14 March 2012

**Modification Application 06\_0184 MOD3 – Response to Submissions  
Pasminco Cockle Creek Smelter Pty Ltd (Subject to Deed of Company Arrangement)**

Figure 1: Concept of proposed geocomposite capping system

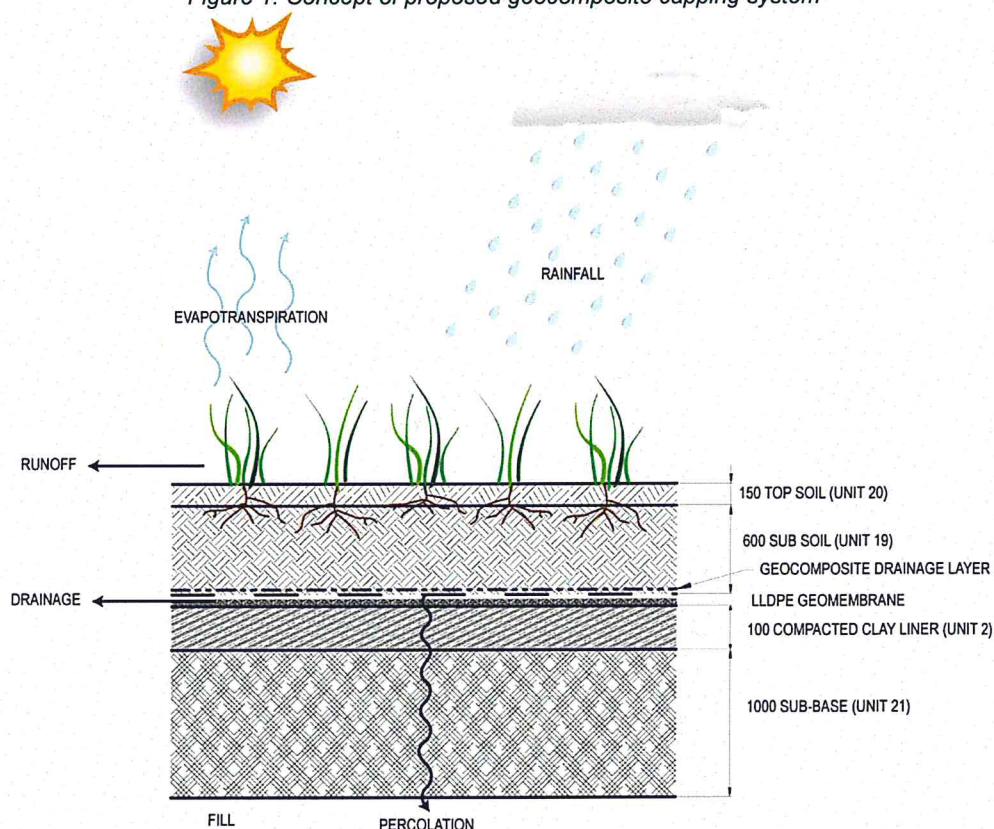
*'The proposal states that the 150mm subsoil gravel drainage layer, with subsoil drainage collection pipes would be replaced with a geo-composite drain of thickness 5-10 mm and that there would be no change to the drainage pipe layout and spacing. In the current design the noted drainage piping system is within the 150 mm subsoil gravel drainage layer which is proposed to be deleted. In what layer will the drainage piping system be located, or what will be the configuration for the placement of the drainage piping system?'*

Comments: The geomembrane should be able to provide equivalent performance to the clay cap.

Comments: The geosynthetic drainage system should be able to provide adequate drainage.

Comments: While this proposed change could increase infiltration, the capping and drainage system if properly designed should ensure that there is no increase in leachate generated.

Each subsoil drainage collection pipe will be positioned directly above the geocomposite drain and will be surrounded by a zone of drainage gravel (defined as Unit 8 in the Technical Specification). The drainage gravel surround will provide a direct hydraulic connection between the pipe and the geocomposite drain. The drainage gravel surround will project approximately 200 mm upward into the 600 mm thick subsoil layer (Unit 19) and will be separated from the subsoil by a filter geotextile (Unit 13).

Detailed design of the system has not yet been performed. During detailed design, dimensions for the gravel surround will be established. Detailed design will also consider the need to slightly lower (i.e. by 50 to 100 mm) the elevation of the capping system liner and geocomposite drain along the alignment of the drainage collection pipe in order to allow the pipe to be positioned with its invert elevation below the elevation of the adjacent geocomposite drain, and to therefore direct greater subsurface flow into the pipe.
